DEPARTMENT OF PUBLIC WORKS

MEMORANDUM

TO: All Staff
FROM: Public Works Plan Review Team
DATE: December 6, 2021
SUBJECT: SX-21-00018 Dekate

SITE PLAN

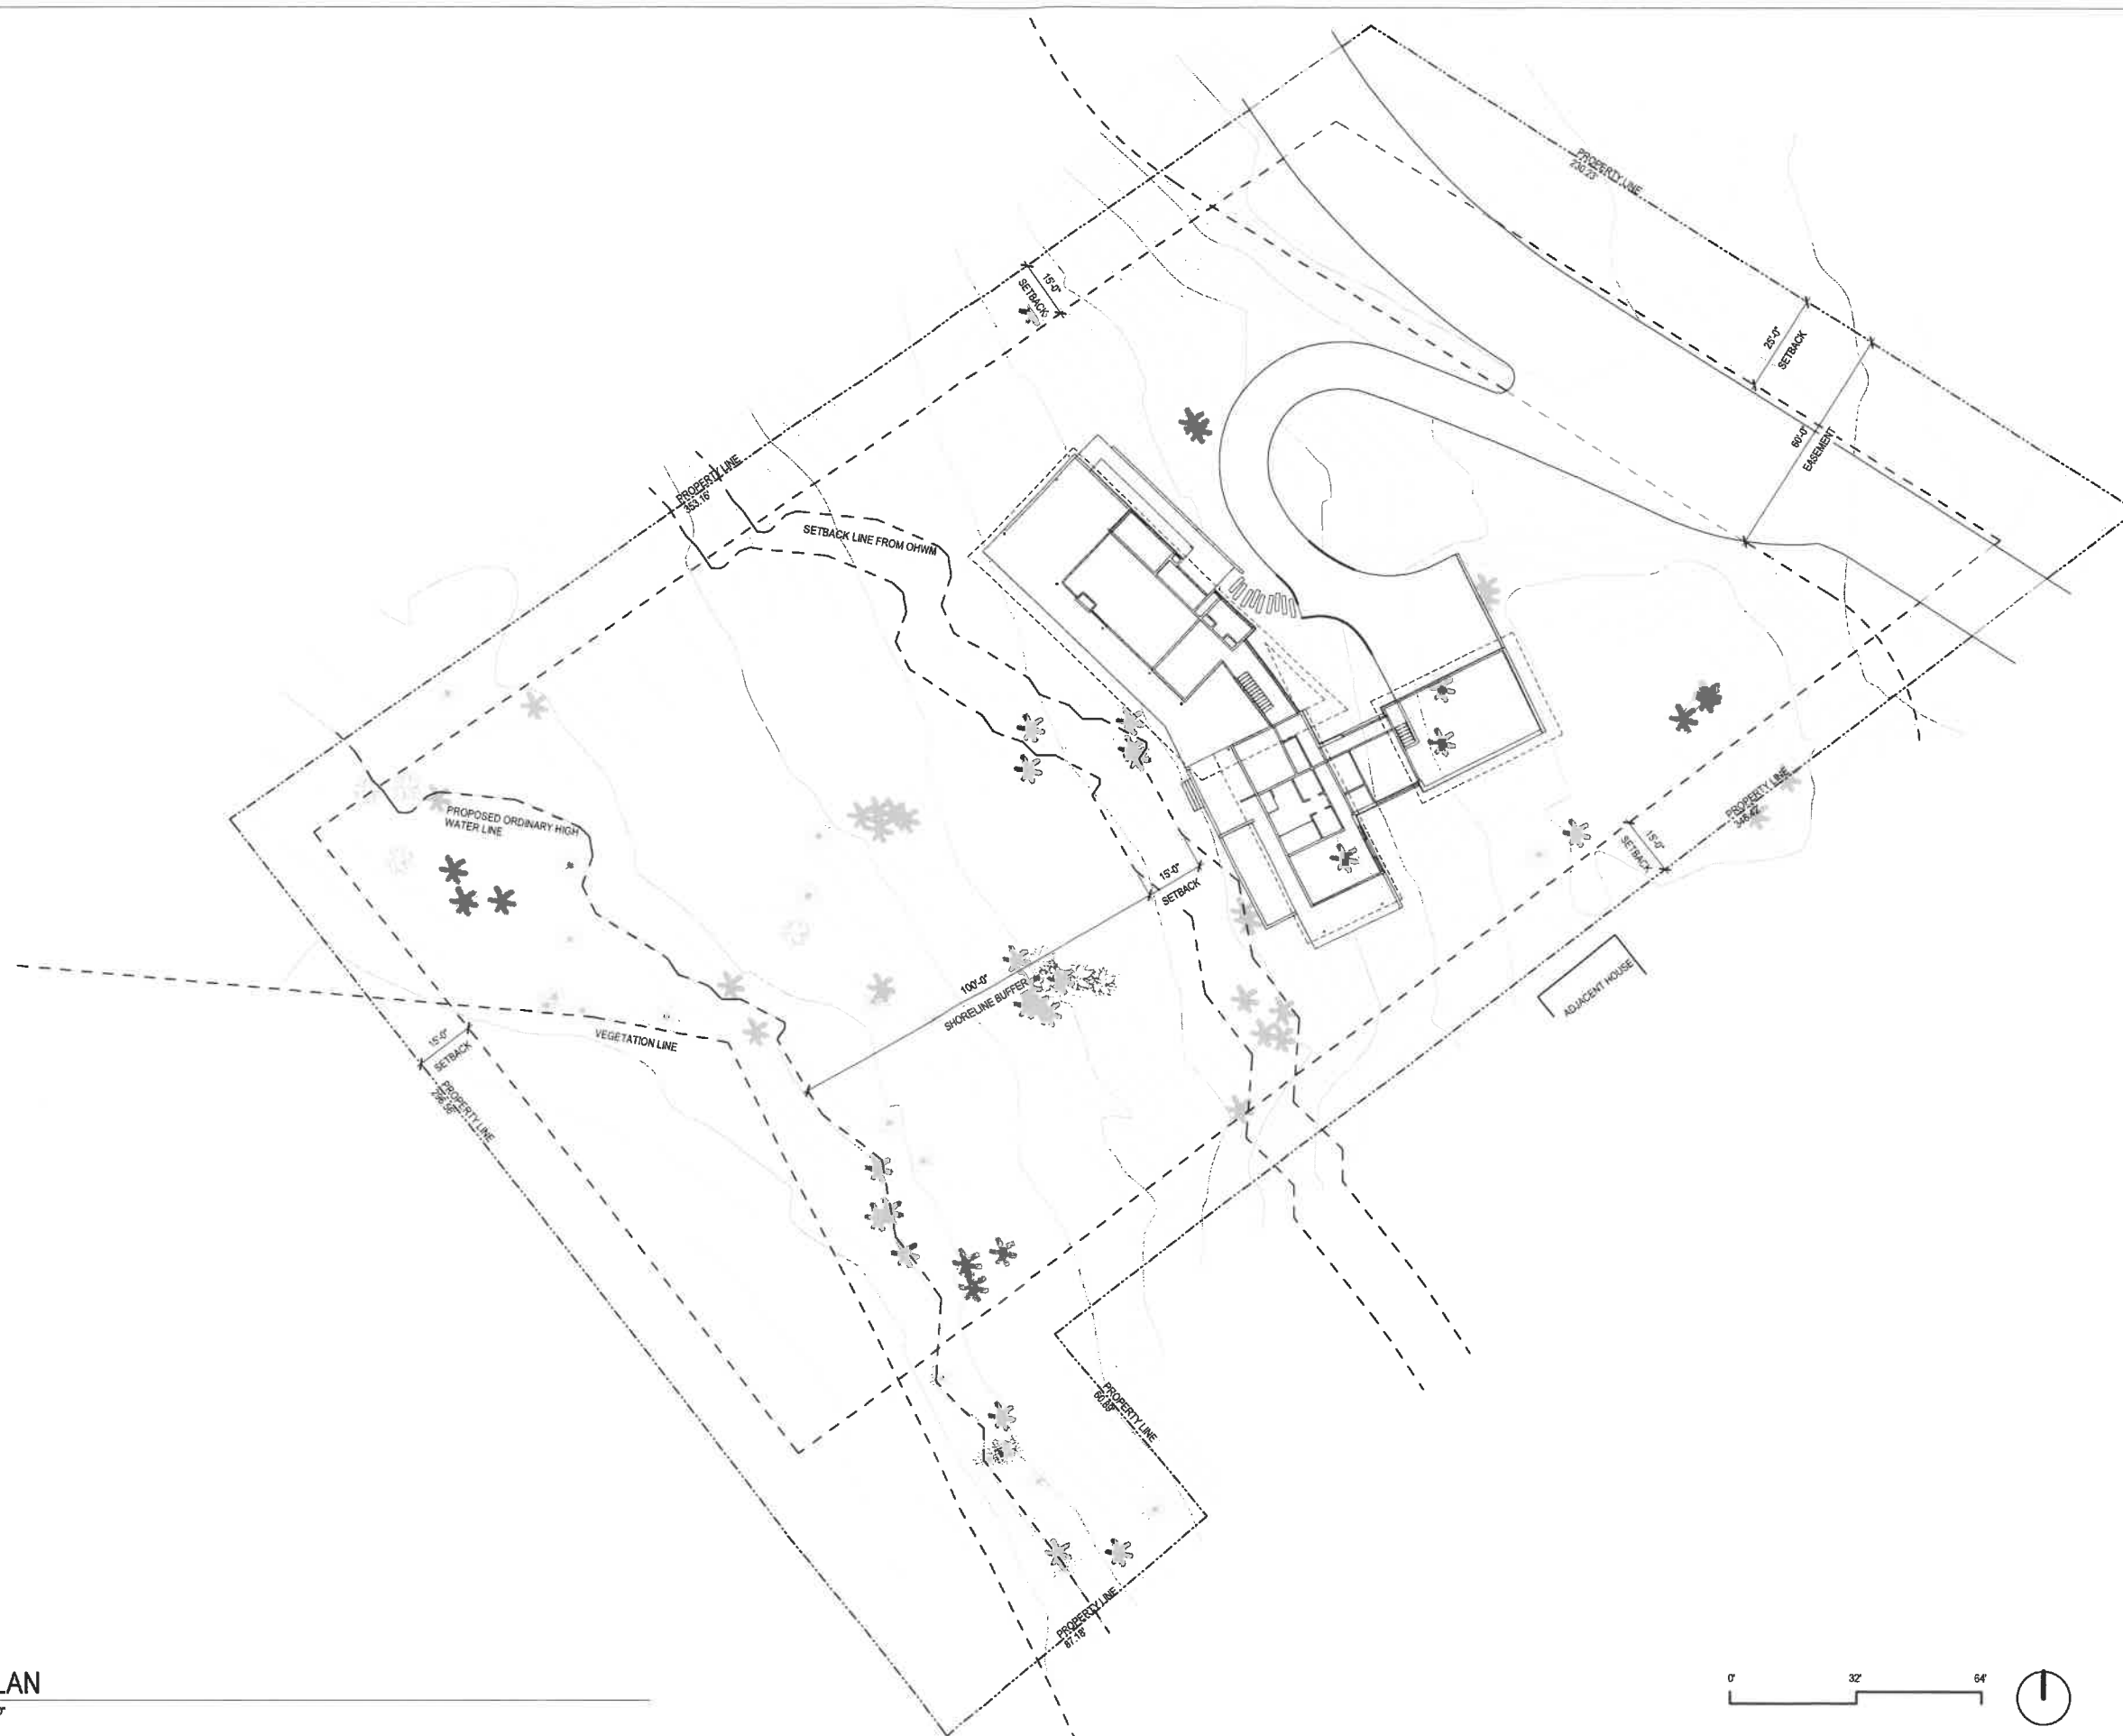
2. The proposed development is outside the FEMA-identified flood zone. A floodplain development permit will not be required for construction of the home in the location shown. Please be advised that any manmade changes within the 100-year floodplain, including but not limited to "buildings or other structures, mining, dredging, filling, grading, paving, excavation or drilling operations or storage of equipment or materials" requires a floodplain development permit.

3. Public Works staff coordinated with the Cle Elum Pool Raise Project Manager at the Bureau of Reclamation on the proposed site plan. We do not have concerns about the proposed location of the single-family residence under current or future Cle Elum reservoir operations.
